SUBJECT: Engineering Review Comment
Mountain View Electric Association Inc. (The Association)

Project Name: Falcon Meadows at Bent Grass Filing 4 – Final Plat
Project Number: SF2223

Description: Proposed development of 39 single family lots located north of E. Woodmen Rd. and Bent Grass Meadows Dr. in Township 13S, Range 65W, Section 01.

TYPICAL LOT
EASEMENT DETAIL

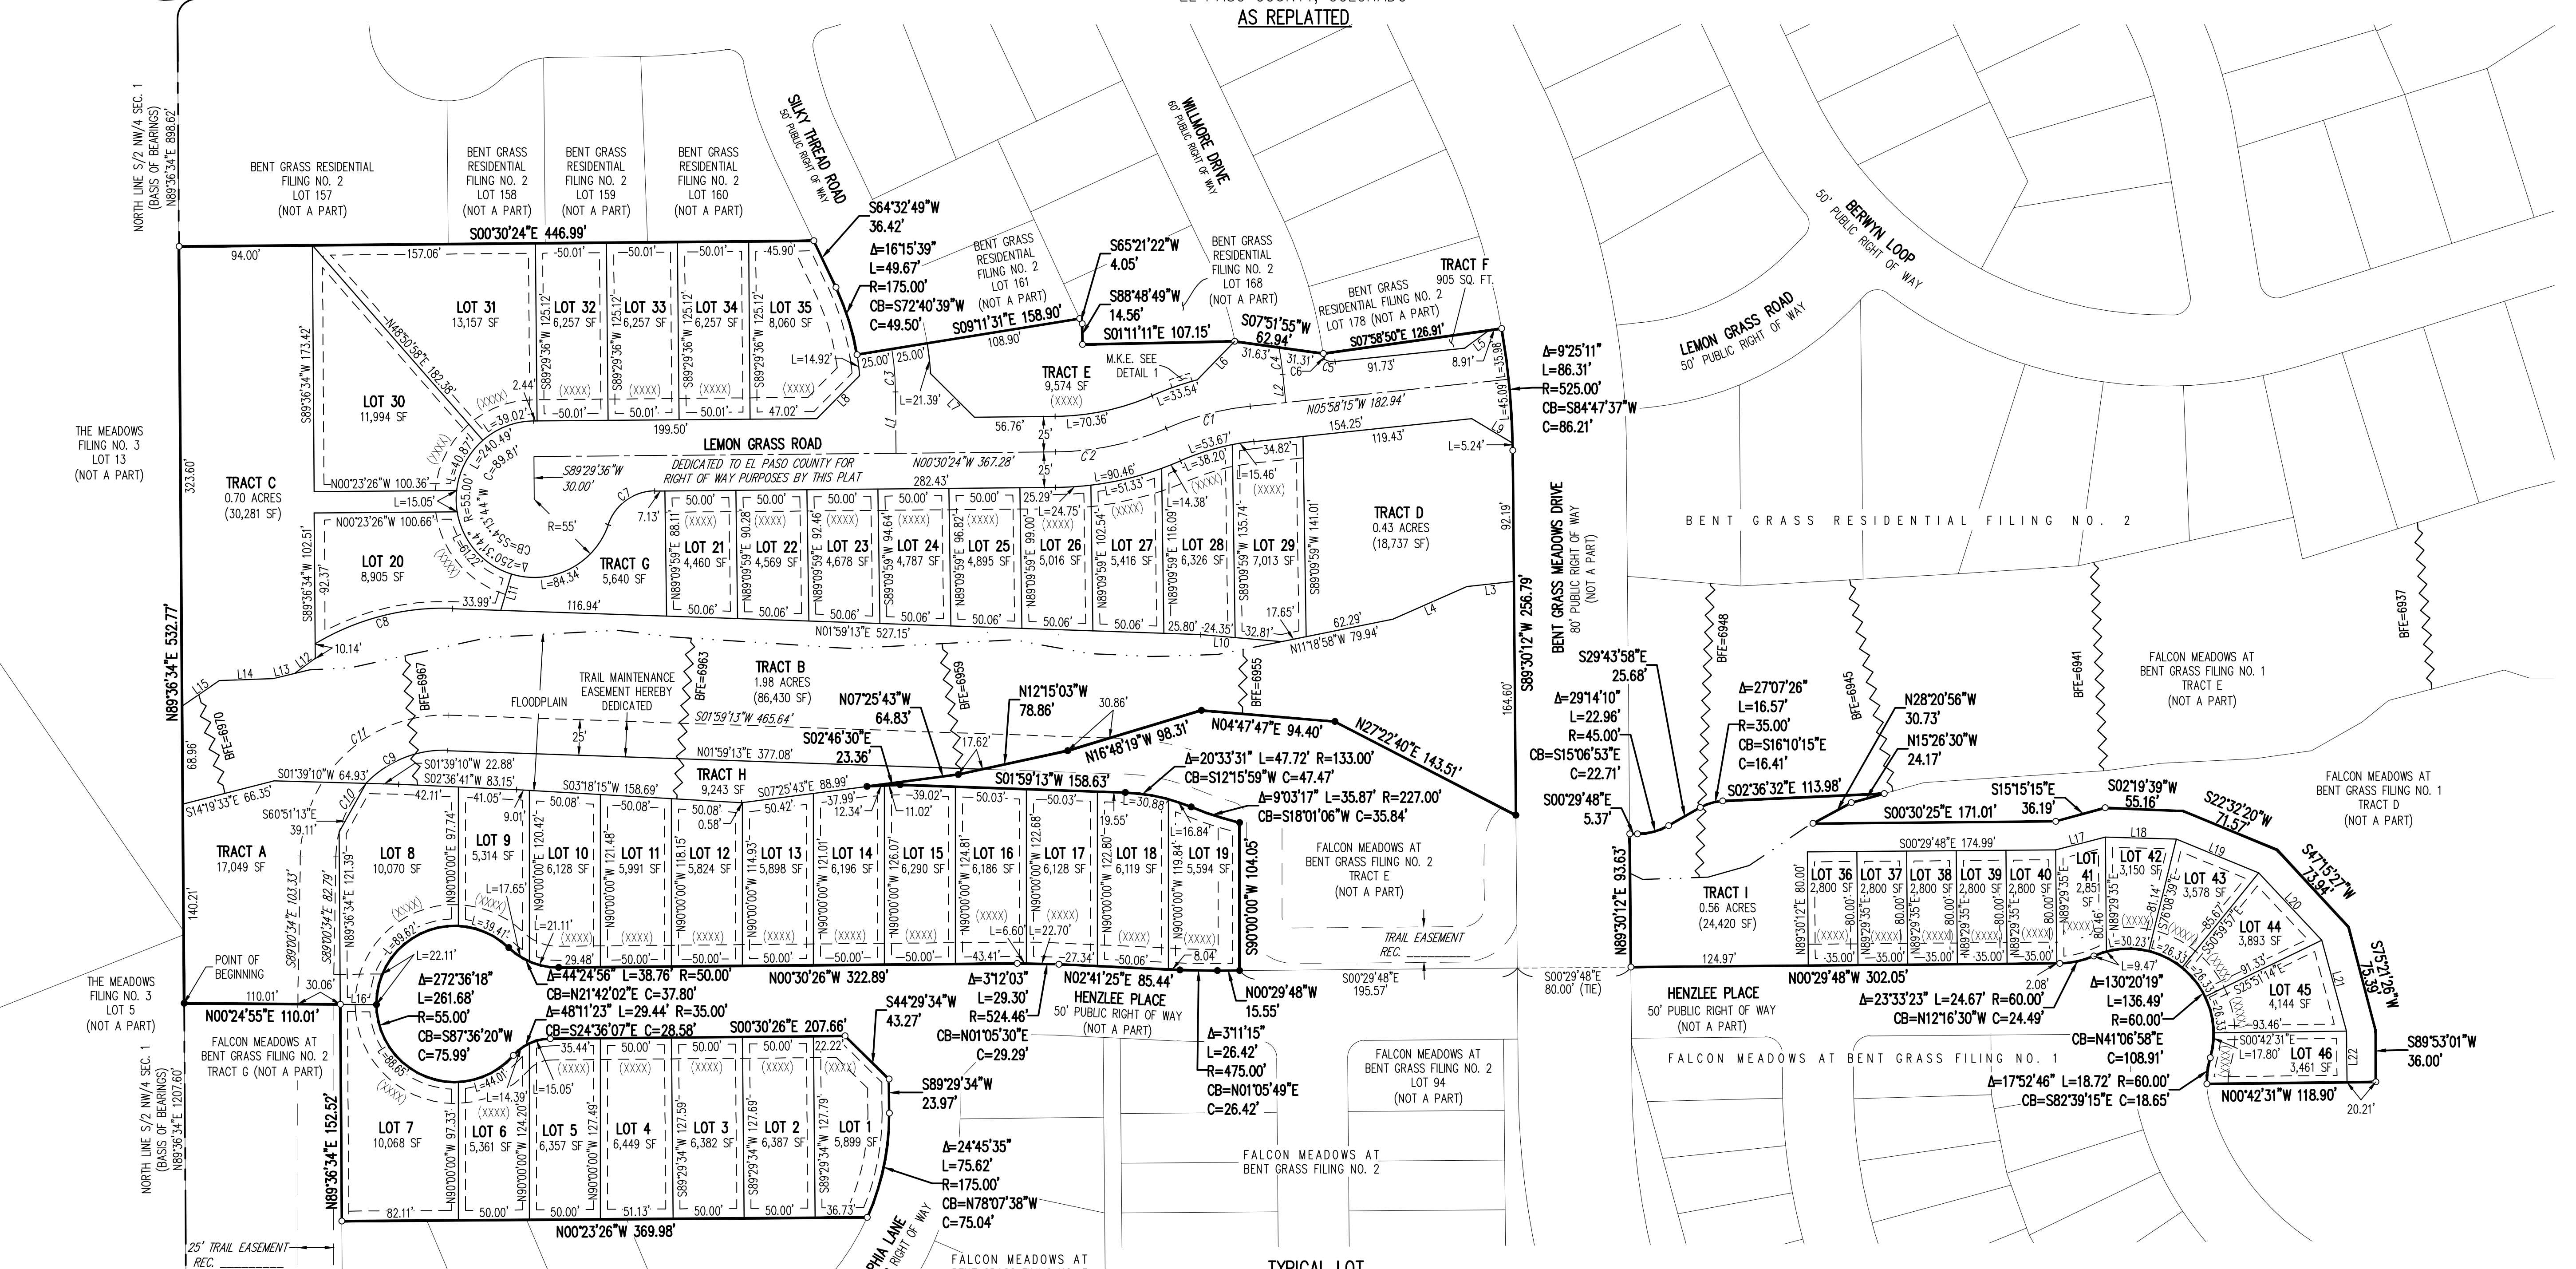
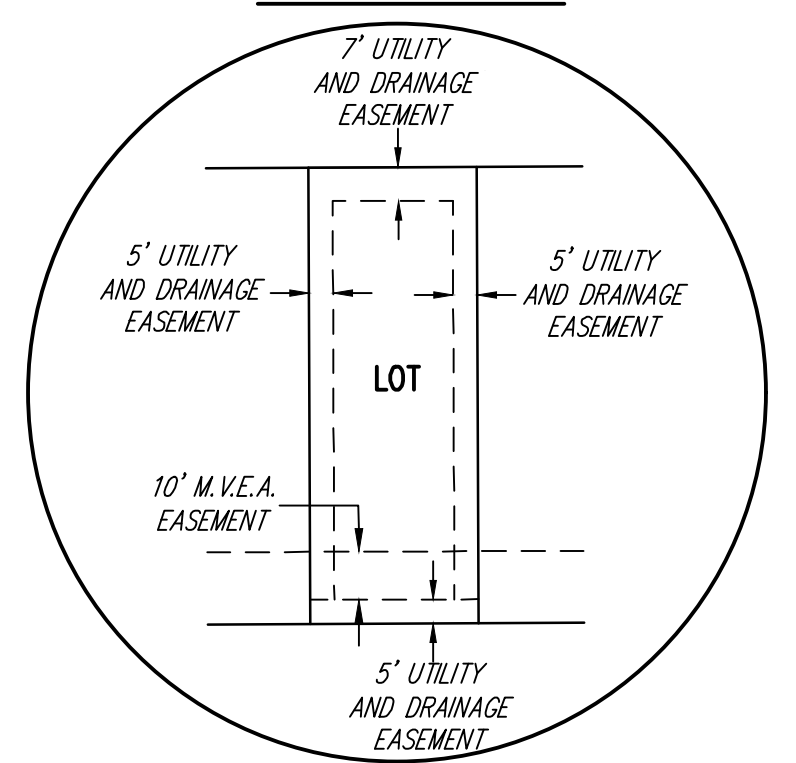
The Association requests a ten (10) foot front lot utility easement in addition to any public improvement easement, a five (5) foot side lot utility easement, and a seven and a half (7.5) foot rear lot utility easement along with a twenty (20) foot exterior utility easement on the plat and all tracts include easements. The Association also requests the platting of the Association's existing facilities with easements on the plat. Additional easements may be required.
